**KIRKLEES METROPOLITAN COUNCIL
INVESTMENT & REGENERATION SERVICE**

DELEGATED DECISION TO DETERMINE PLANNING APPLICATIONS

Reference No:	2023/62/93040/W
Site Address:	18, Wood Street, Slaithwaite, Huddersfield, HD7 5EE
Description:	Erection of single storey rear extension
Recommending Officer:	Joanna Rednall

HOUSEHOLDER DELEGATED REPORT

Proposed ground floor layout (1:50)

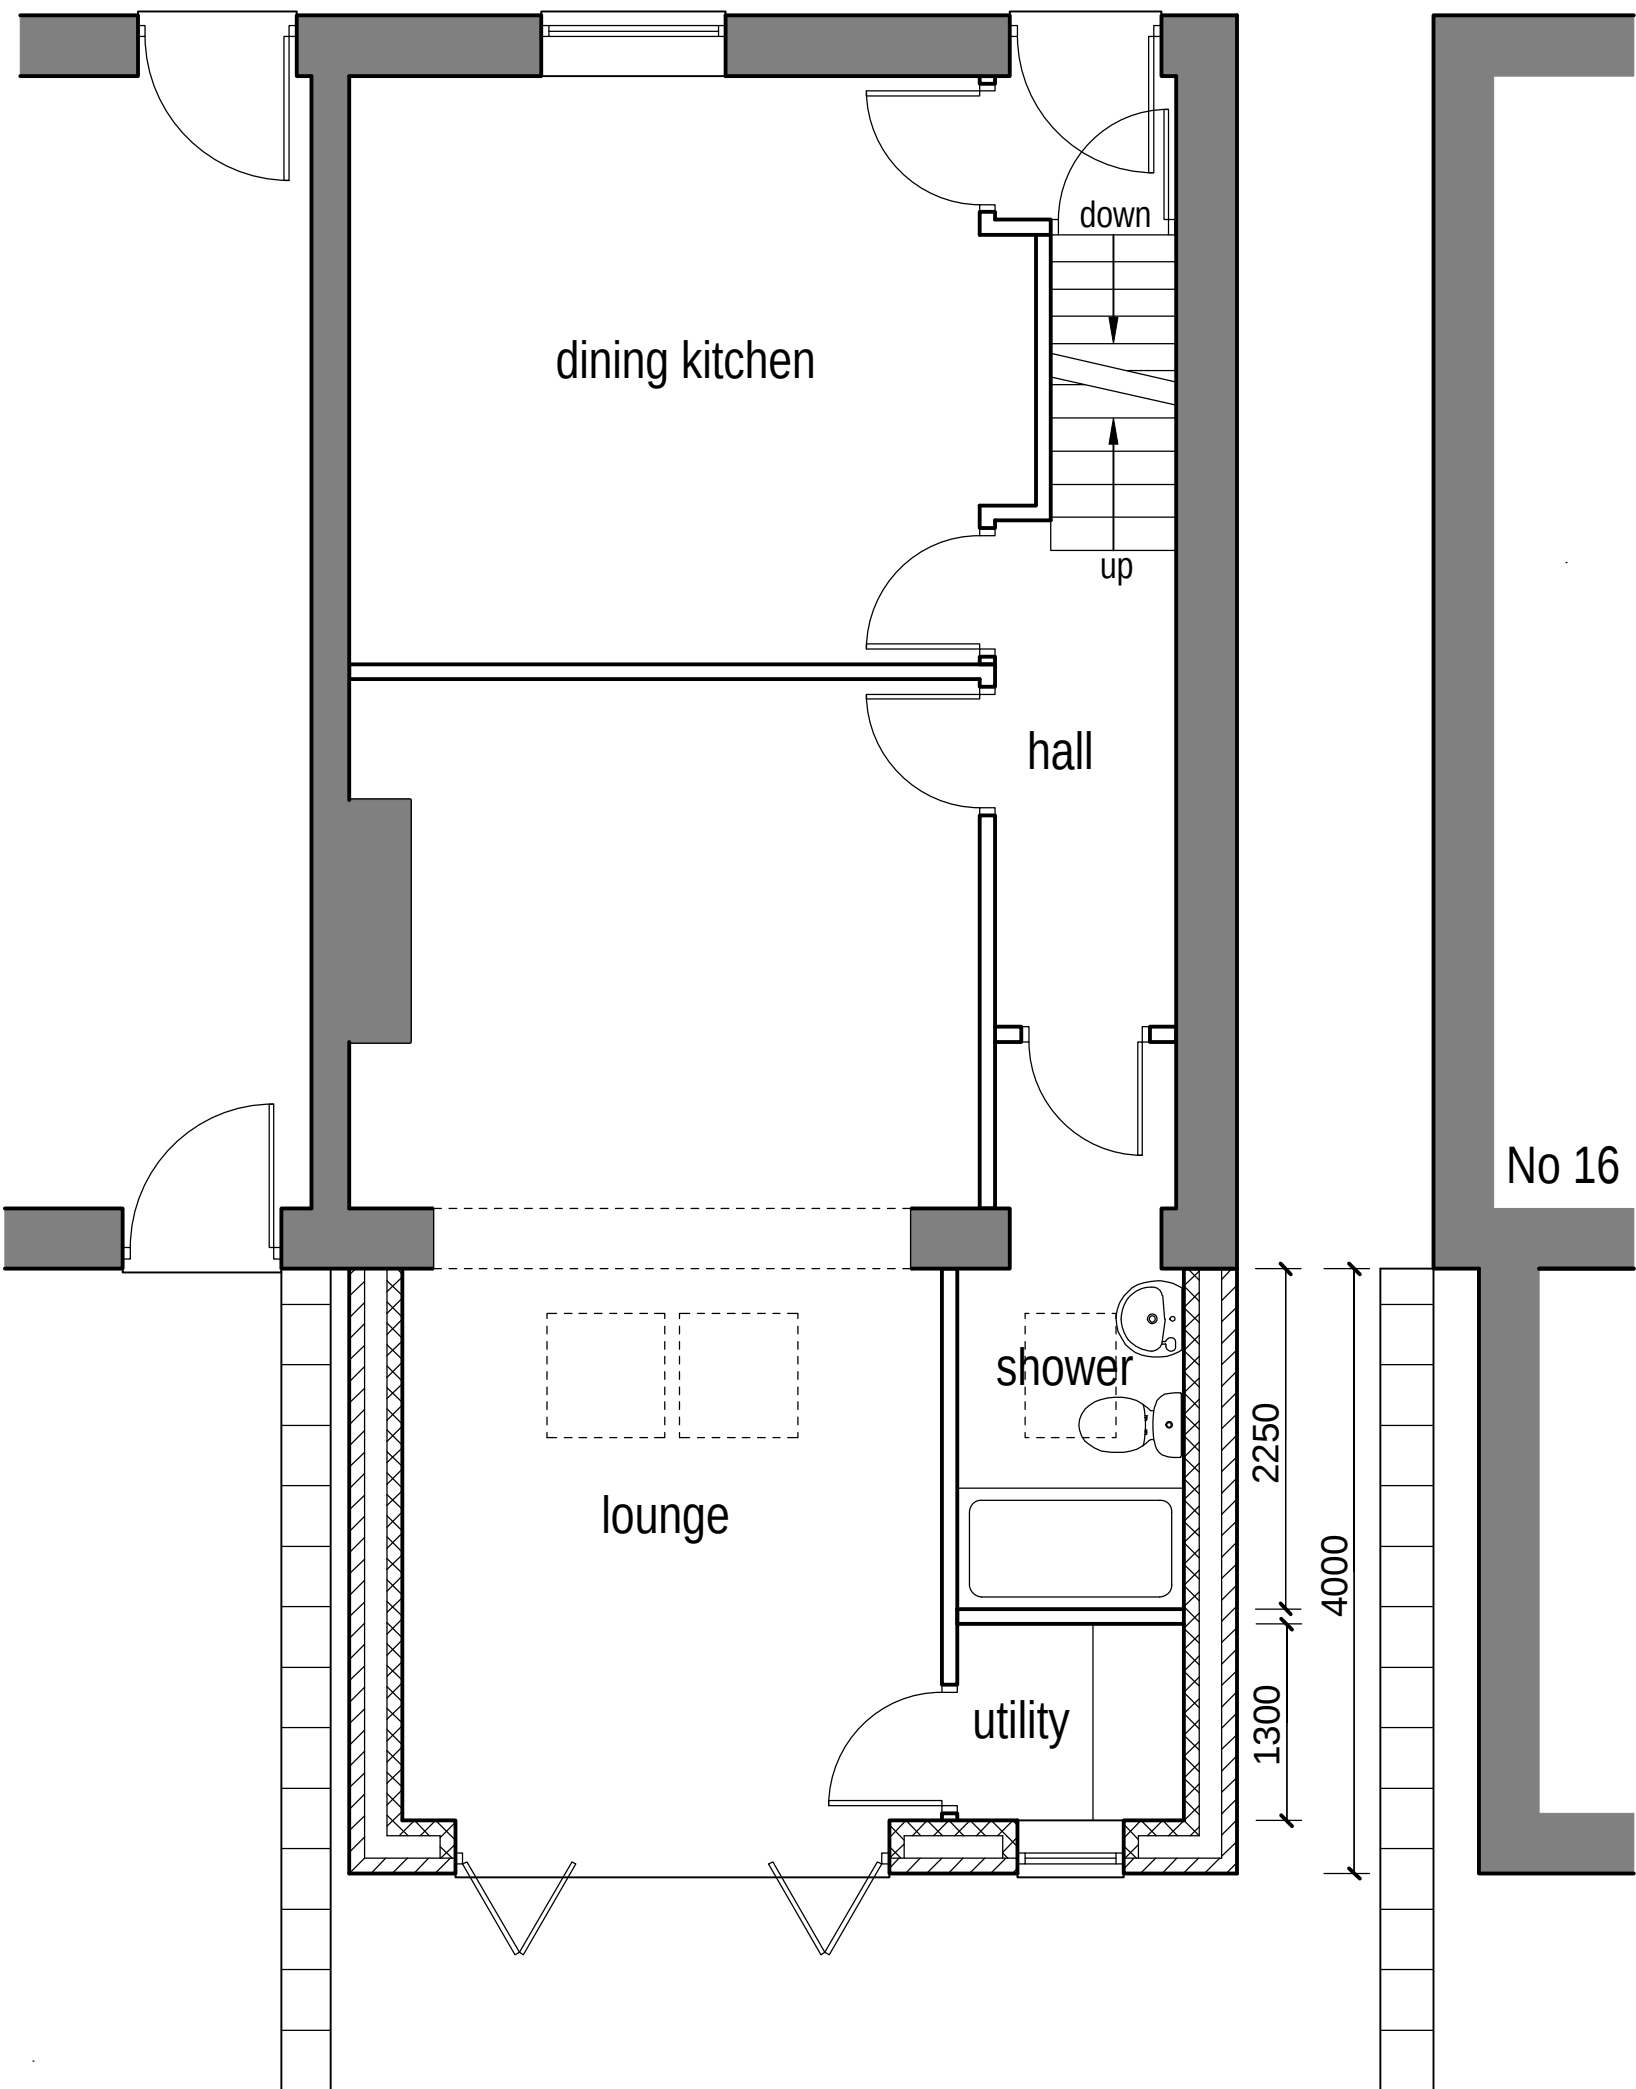
YES / NO	SUMMARY
Negotiations/Amendments during course of application	Yes	The case officer recommended consideration be given to amending the scheme with regard to: • Reducing the projection to be in line with the SPD • Accessing the rear openings of the extension given the gradient of the site. • The under build of the extension

The application seeks permission for the erection of a single storey rear extension. The extension would project a total of ~4.3 metres and leave a ~0.13 metre gap between the boundary of the neighbouring detached property. The north elevation would lie flush with the existing side elevation. The eaves height would be ~1.3 metres with an overall height of ~1.9 metres to the ridge of the lean-to roof. Construction materials of the walls would be stone and the roof would be blue slate.

Plan showing 45° line from centre of neighbouring window (1:100)

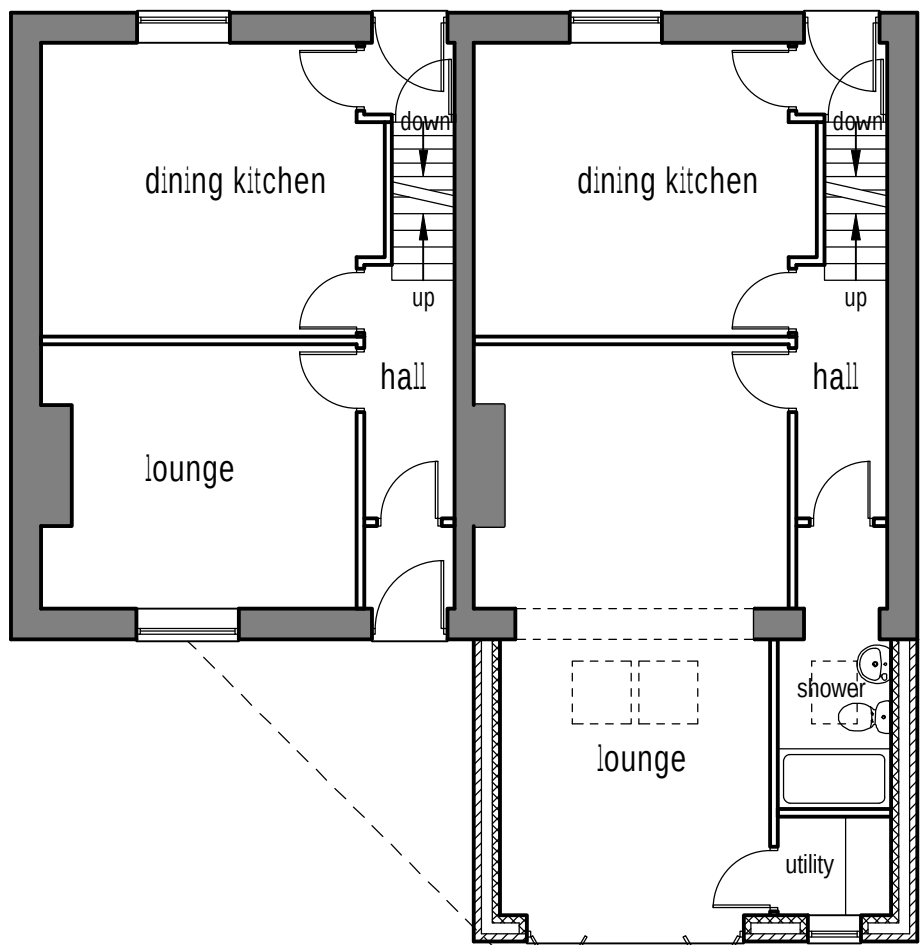
Where they exceed 3m in length the eaves height should generally not exceed 2.5 metres	Yes – the eaves height would not exceed 2.5 metres	
Retain a gap of at least 1 metre from a property boundary, such as a wall, fence or hedge		No – the extension does not retain a 1 metre gap from the south facing boundary shared with No.20, however the 45 degree line from the habitable window at No.20 and the extension of the application property is met.

- *20 Wood Street – attached neighbour on the south facing elevation – set on same ground level and boundary treatments consist of a ~1 metre wall and trees – 45 degree line from the rear extension to habitable window would be met. In addition the orientation of the site, with this property being south of the host dwelling would mean overshadowing is less severe.*
- *16 Wood Street – adjacent neighbour on the north facing elevation – detached dwelling set on the same building line and ground levels - rear wall of number 16 has been extended by approximately 3.3 metres beyond the existing rear wall at the application property.*
- *There are no properties within close proximity to the rear boundary of the application property which would be affected by the proposal.*
